**Consultation Response from KC,
Lead Local Flood Authority**

2023/93539 Land adj, Ledgard Bridge Mill, Back Station Road, Mirfield, WF14 8NZ

Date Responded: 23rd October 2025

Project: Proposed residential scheme at Ledgard Bridge, Mirfield
 Client: Birks Executive Homes Ltd, Cawthorne, Bamsley S75 4EJ
 Dwg Title: 170012_Site Plan
 Scale: 1:200 @ A0
 Date: Jan 22

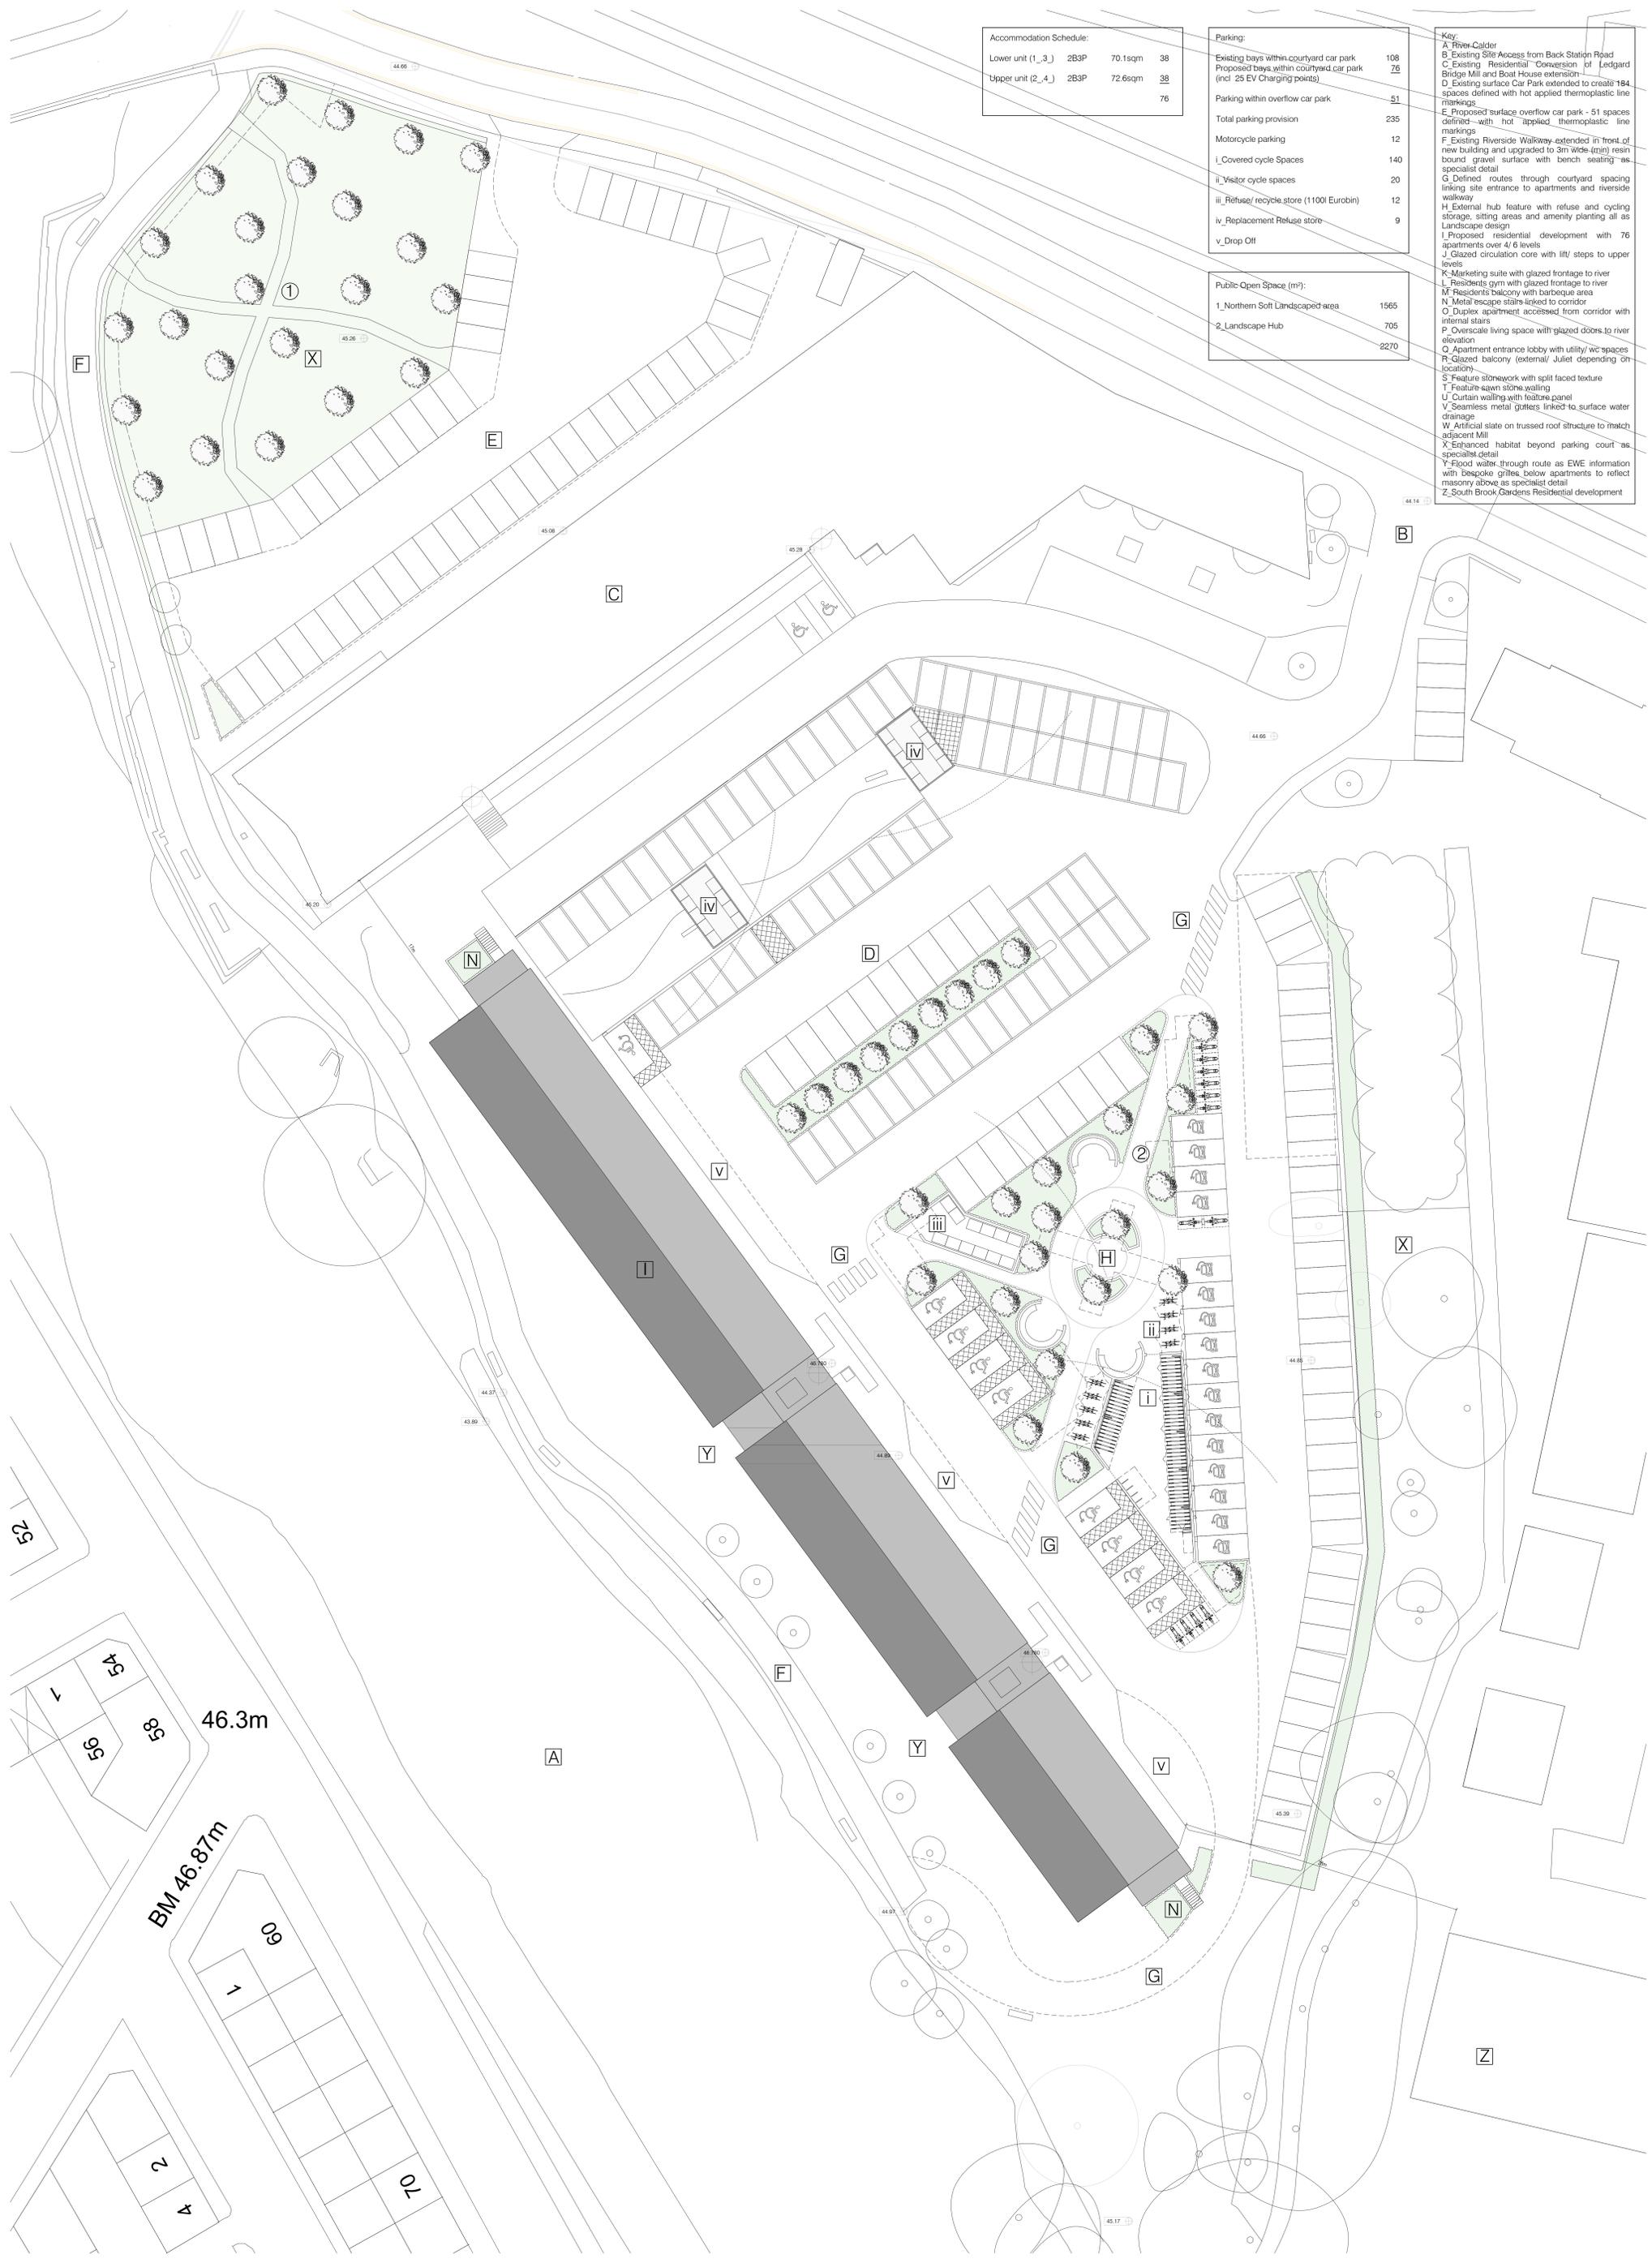
There still doesn't appear to be an analysis of depth of flooding where 'elevated walkway' is located and the areas of the bridge adjacent to the emergency platform. It does appear that this is the best that can be achieved in terms of meeting Ledgard Bridge. We would require clarification on the elevated walkway drawing that is labelled 'existing ground level' 'flood level' but nor 'walkway level'. Clarity over safety of the evacuation route is required.
